# City of Albuquerque Stormwater Construction Site Inspection Report

Project Name:	Champion Xpress				
Location:	4516 Wyoming Blvd				
Site Contact Name & Agency	Jordan - 7Building & Dev.	ESC File No.	F20E005		
	<a href="mailto:jordan@7bdev.com">jordan@7bdev.com</a>	NPDES Id. No.	NMR10028A		
Inspection Date:	01/27/20	Start/End Time:	1350/1420hrs		
CoA Stormwater Inspector:	Timothy E. Sims				
Construction Phase:	foundations				
Type of Inspection:	<input checked="" type="checkbox"/> Regular	<input type="checkbox"/> Storm Event	<input type="checkbox"/> Post Storm Event >0.25"	<input type="checkbox"/> 311/Complaint	<input type="checkbox"/> Follow Up

StormWater Pollution Prevention Plan (SWPPP) Sheet 1 of 2

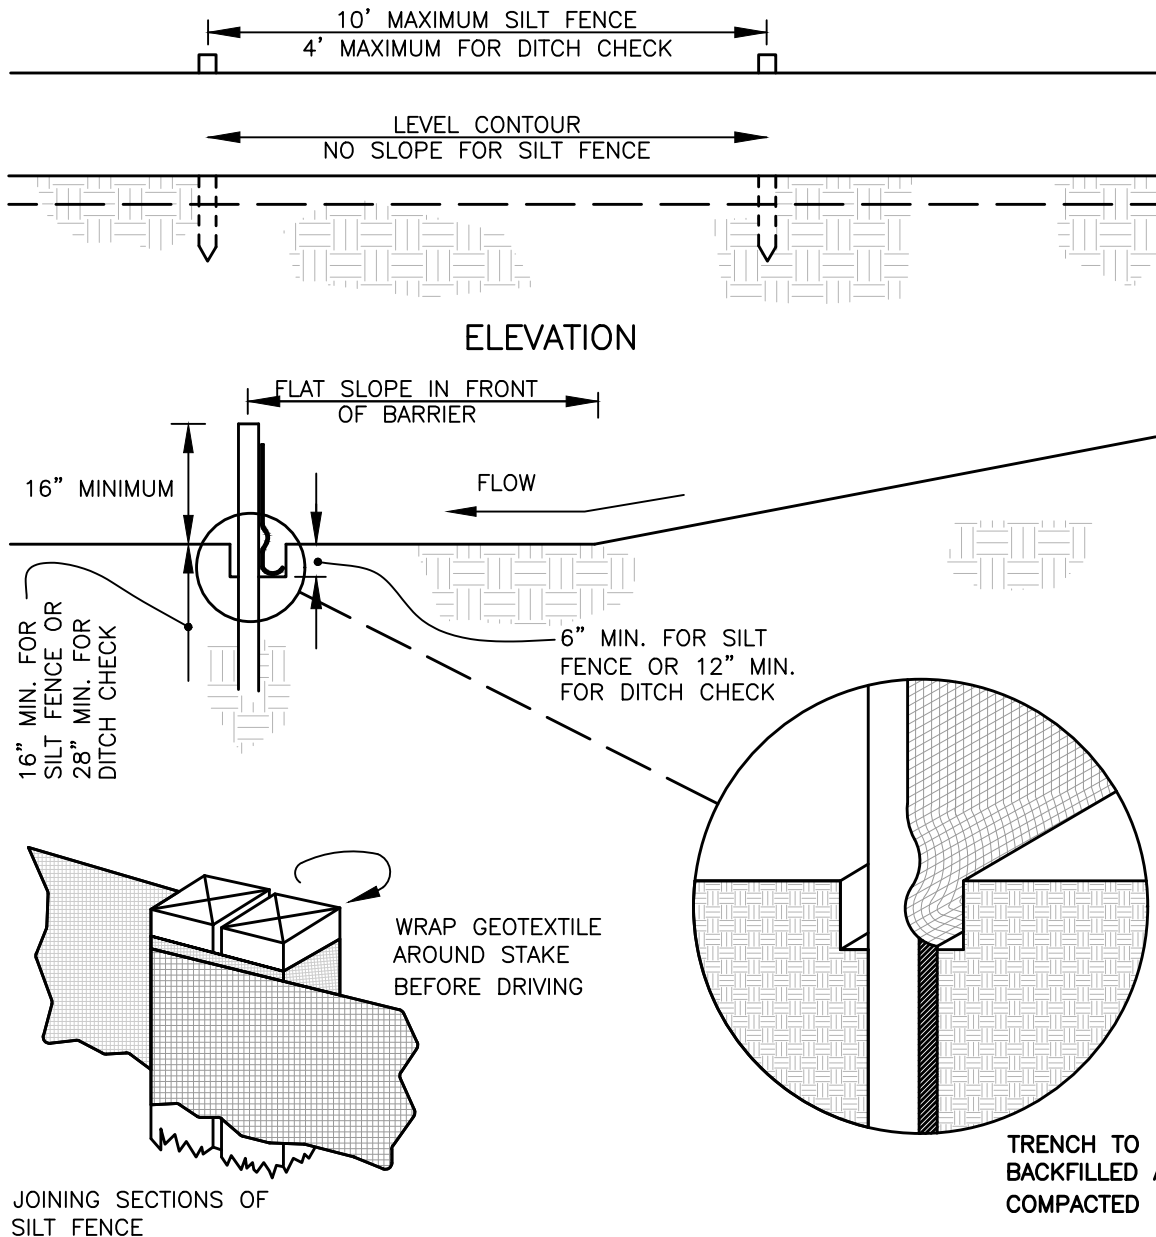
Item Number	Deficiency/ Corrective Action		
1	Please prevent trackout from entering the inlet on the NE corner of the site. This inles should be protected. Installation of the trackout pad or persistant sediment removal in this area is another option.		
2	Install additional sediment BMP at the existing access points off of Wyoming.		
3	Please provide latest SWPPP self-inspection report.		
2.1	Discharge off site? (Y/N)	No	
4	Self Inspection Reports	requested	Latest report Date: not on file
